DECISION DELEGATED TO HEAD OF PLANNING

Application No: H14-0678-26 **Applicant:** Mrs T Hull
Proposal: Proposed first floor extension and alterations
Location: 25 Orchard Close Pinchbeck Spalding
Terminal Date: 14th September 2026

J218-PL 2B

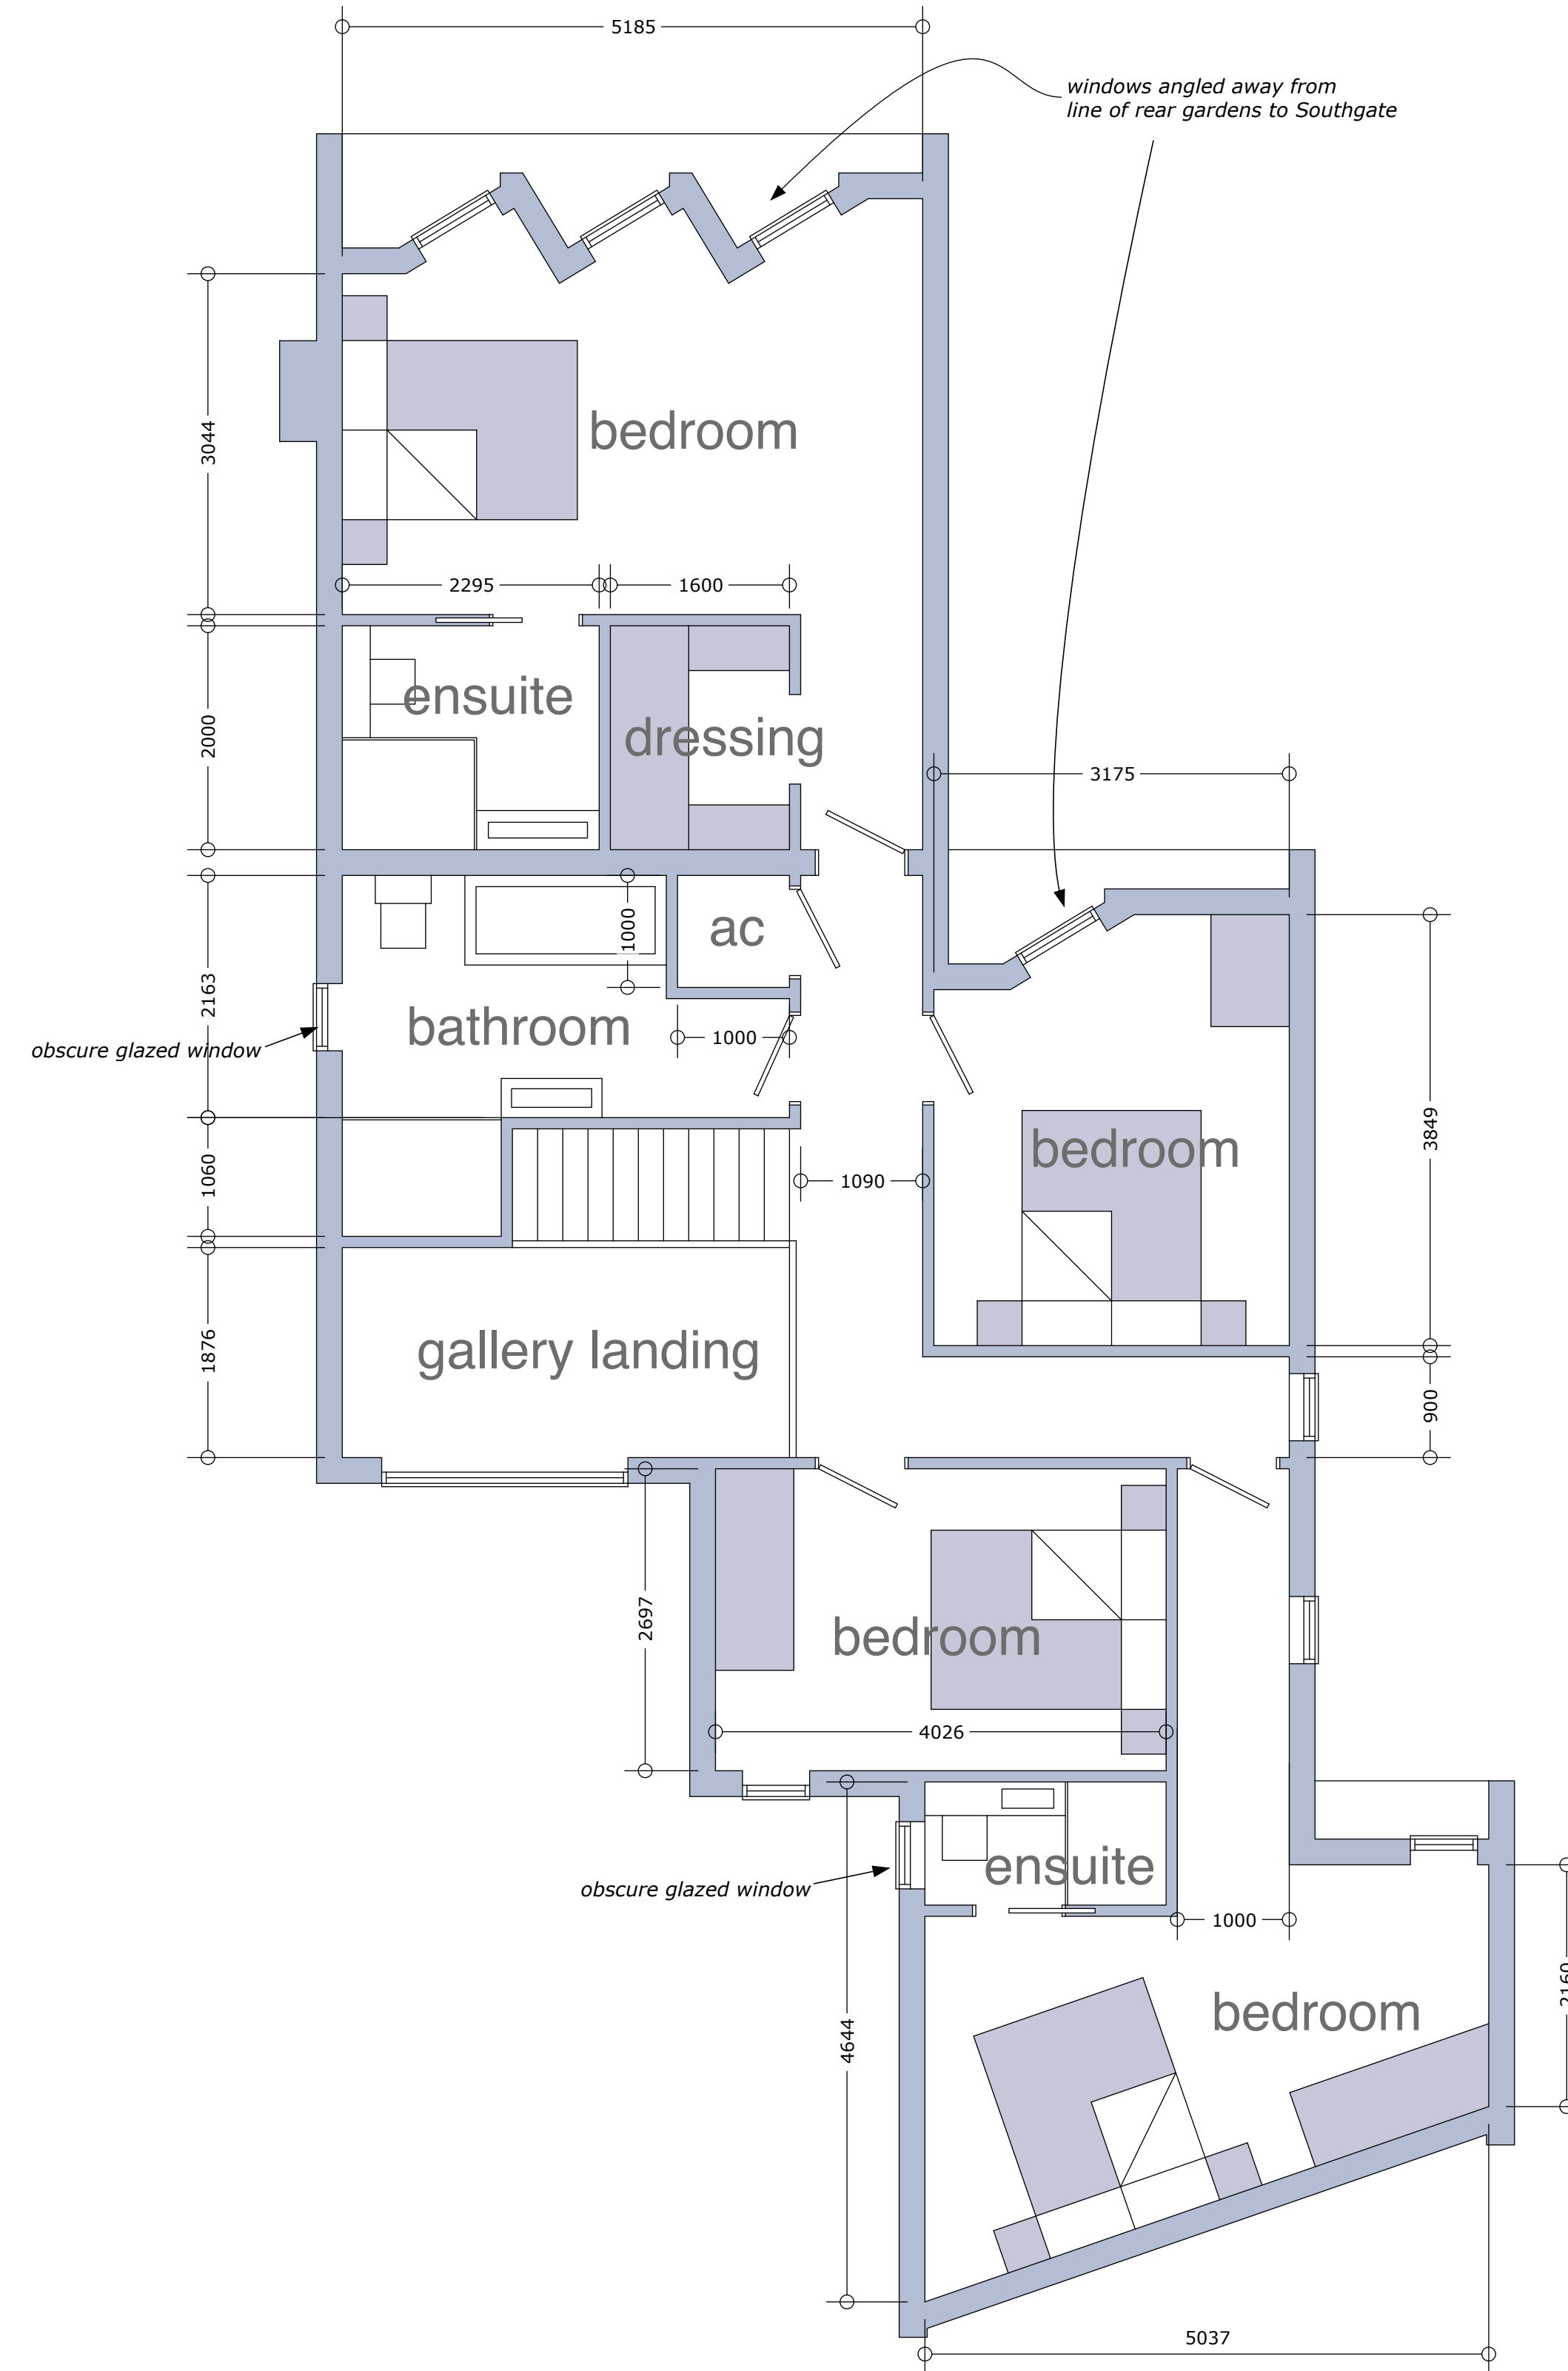
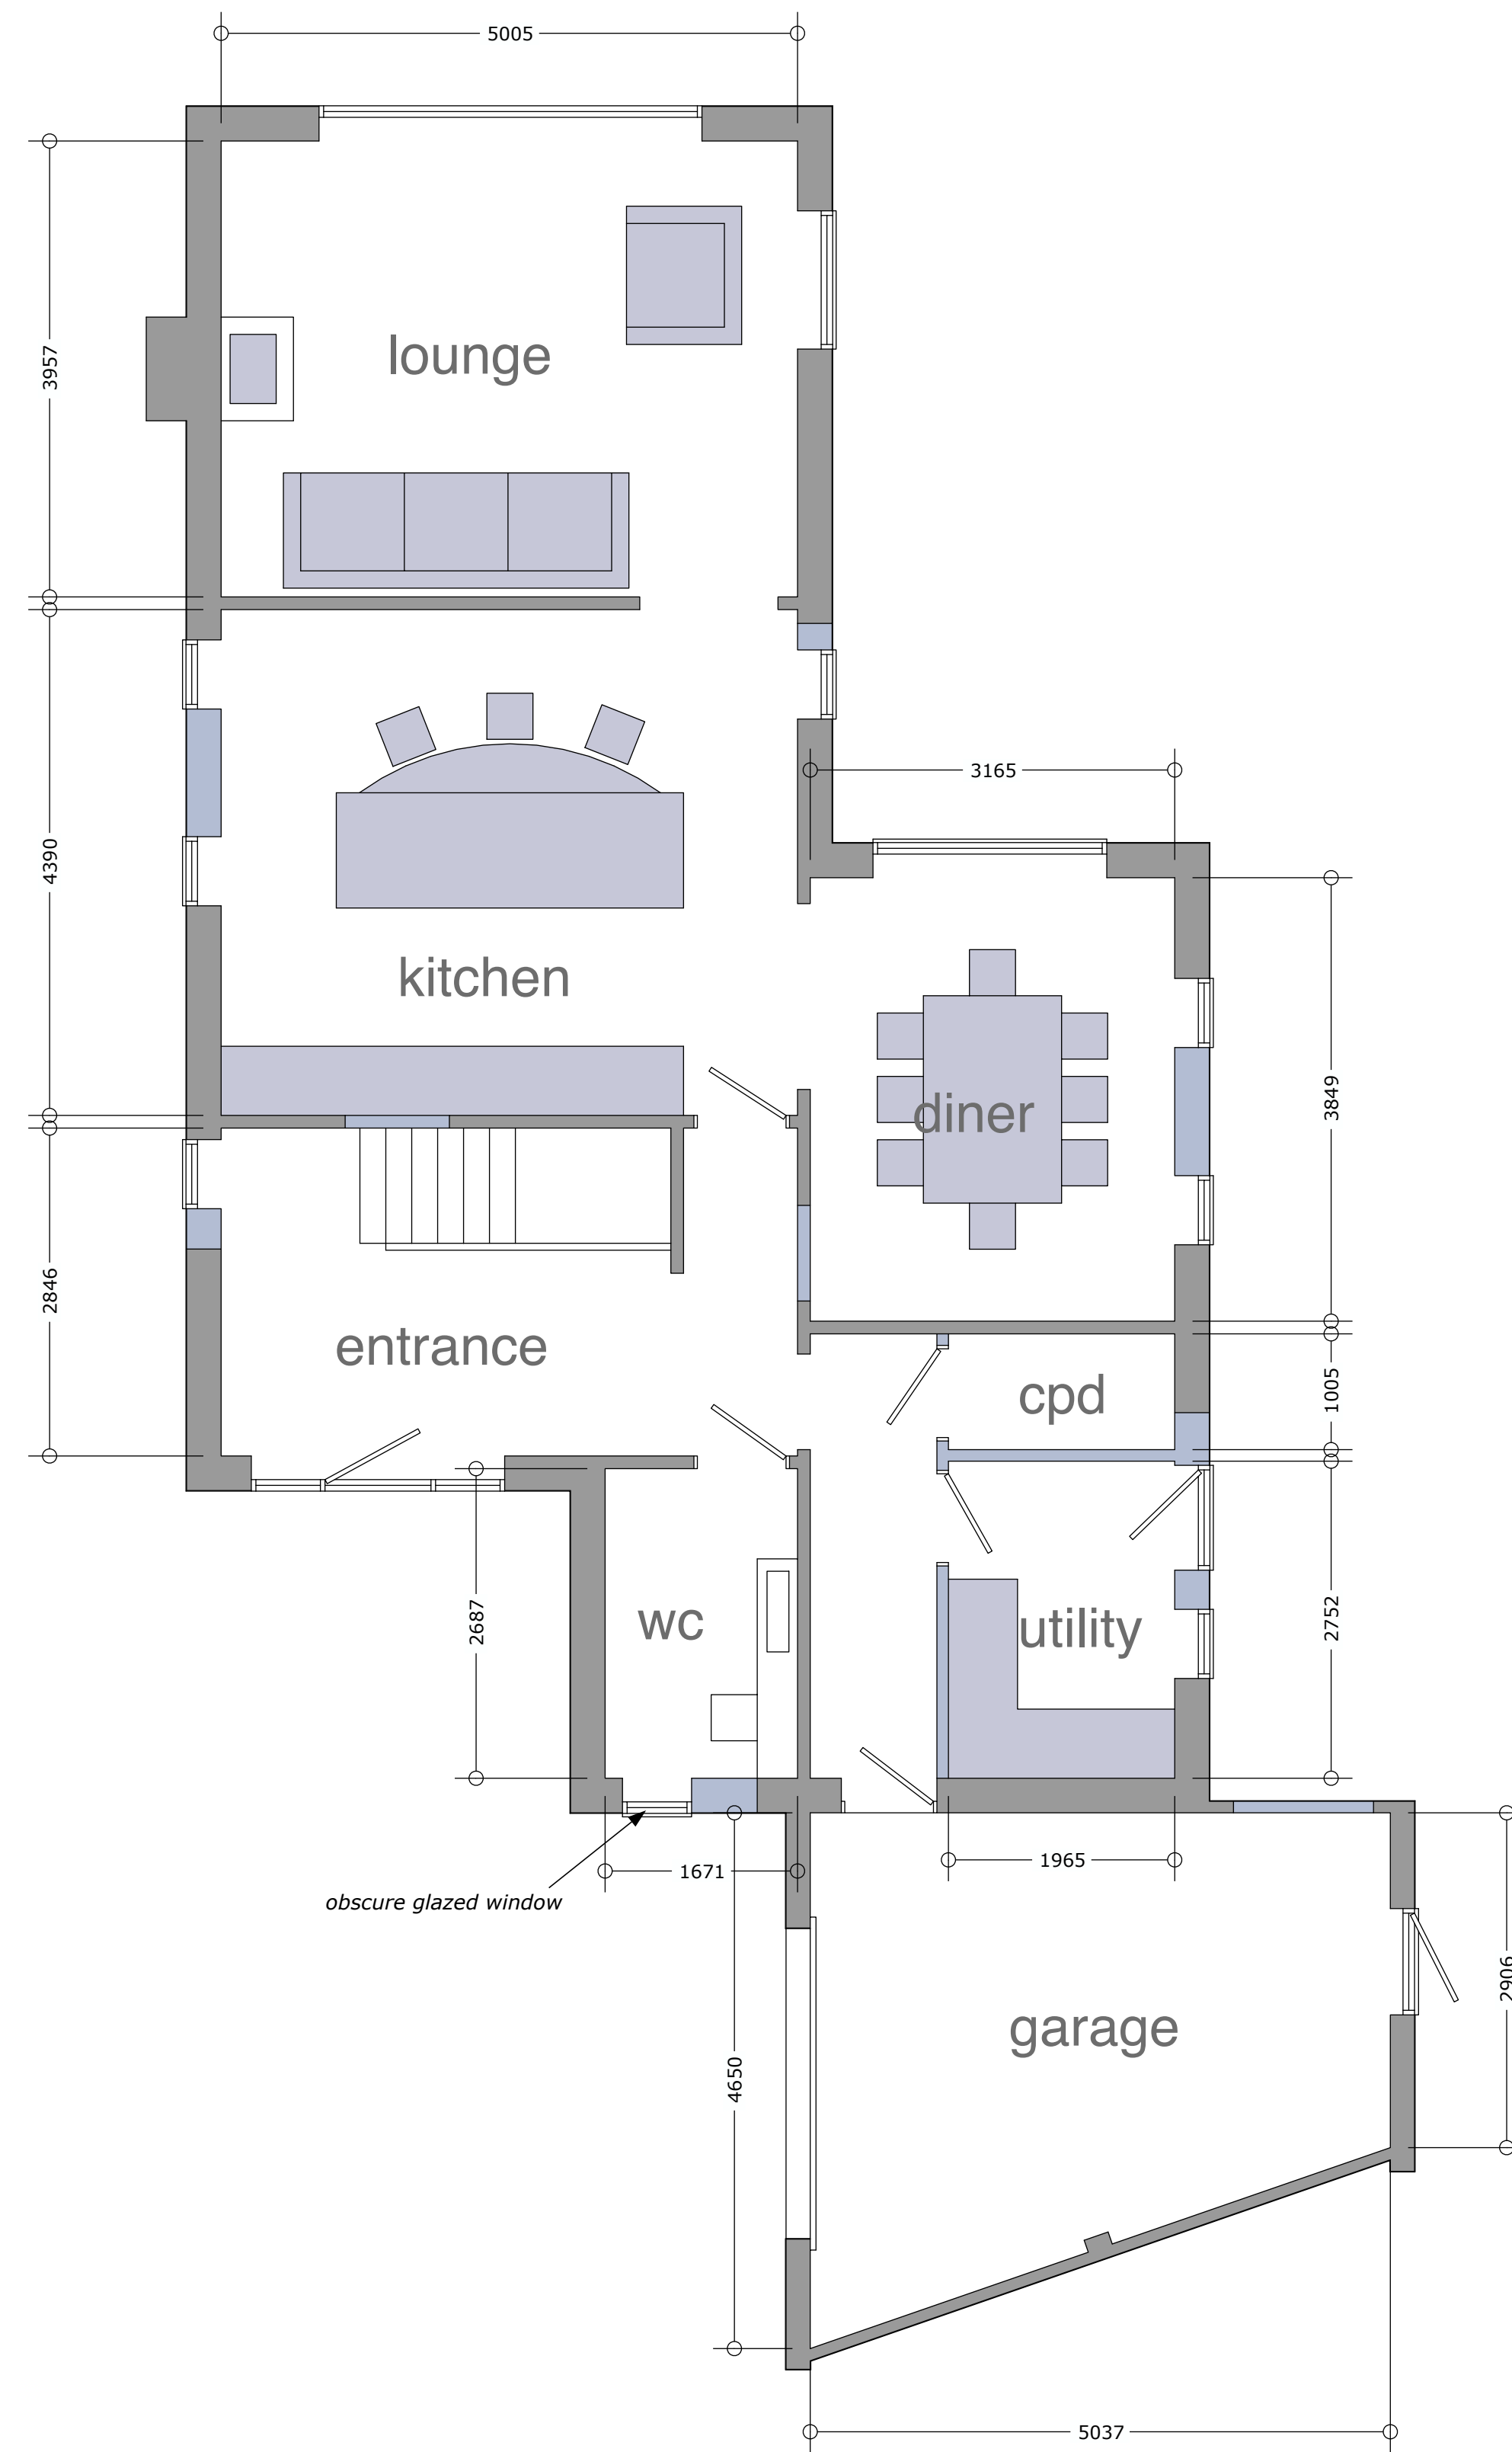
As outlined above however, the proposal seeks to create a first floor extension with first floor space within the existing bungalow. It seeks to achieve this via a 1800mm increase in height to take the total height of the property to 6500mm as well as having the new first floor have a total footprint of 123sqm and thus taking the total footprint to around 240sqm. This increase in floor space works out at around an 84% increase in total.

This increase is considered to be vast in this regard and would be to a materially harmful level

which cannot be supported by the LPA. Furthermore, the increase in height and overall design of the extension would be such that it would bear no resemblance to the existing property nor that to any in the immediate area as a result of the significant design changes proposed. Whilst there are clear examples of two storey dwellings along Orchard Close and adjoining streets (Southgate and Harpe Close) and thus a two storey dwelling would not necessarily look out of place, the main issue in this instance relates to the significant increase and overall disproportionate design within the application site itself.

Not only are there significant concerns as a result of the main bulk that has been proposed, the materials featured would be vastly contradictory in comparison to the existing built form. The existing bungalow features a relatively standard design through brickwork and a tiled roof, the proposal seeks to alter this through the incorporation of off white rendering over the existing bricks on the ground floor, natural slate cladding and dark vertical cladding around the windows to the first floor. Furthermore, the roof would be constructed from dark grey metal as well as there being dark aluminium for the windows.

Further to this, it is evident that the proposal has taken a modern design philosophy through the use of the materials as well as various elements of glazing and the angled roof slopes across each elevation. This modern design is considered to juxtapose adversely with the existing residential area which features very standard and typical designs and would result in significant harm to the character of the area as a result of this also.

Starting from the front, the bedroom within the window faces towards the rear and should not cause any material harm due to the distance to the boundary. The en-suite which serves this bedroom features a window, however this would be obscure glazed due to the use of the room. The bedroom directly to the rear of this has a small window which faces forwards and outlooks onto Orchard

Close and its neighbours driveway, this view would also not be materially harmful. Alongside this, three windows have been proposed within the landing/gallery area, this is a non-habitable section of floor space and therefore cannot be assessed as providing a materially harmful outlook. Moving back, a main bathroom features a single side window which would be obscure glazed. Adjacent to this, another bedroom would feature one window which would be angled away from its neighbours and face towards the wall of extension, this angle would ensure any view would not be materially harmful.

Finally, the main bedroom to the rear of dwelling features three angled windows on the rear elevation which are faced away from the rear gardens along Southgate. It is considered that these windows would face towards the properties along Harpe Close, most notably No. 23 and 25. The closest window towards the boundary of No. 23 is a total of 9m away with this distance being considered minute and not separated enough to reduce the harm. In an attempt to combat this, it has been outlined that to reduce any overlooking into the gardens of the 23 and 25 Harpe Close, three red acers would be planted along the boundary. Despite this, the LPA are unable to condition that these trees should remain on this boundary indefinitely and therefore cannot be considered as a permanent element of concealment and would not adequately reduce the overlooking from these windows. The overlooking as a result of this is considered to be materially harmful and would see a permanent loss of privacy and should be refused on this basis also.

The proposal comprises a first floor addition which will significantly increase the height of the dwelling from 4700mm to 6500mm. The extension itself would be approximately 1422mm to the north western boundary, 6395mm and 6441mm to the south western boundary and 5742mm to the eastern boundary. As such, it is considered that the dwelling itself is in close proximity to the neighbouring boundaries, whilst this currently is not an issue due to the site featuring a bungalow, should the extension be approved and constructed it would see an adverse and material increase from an overbearing perspective and would appear visually dominant as a result of this.
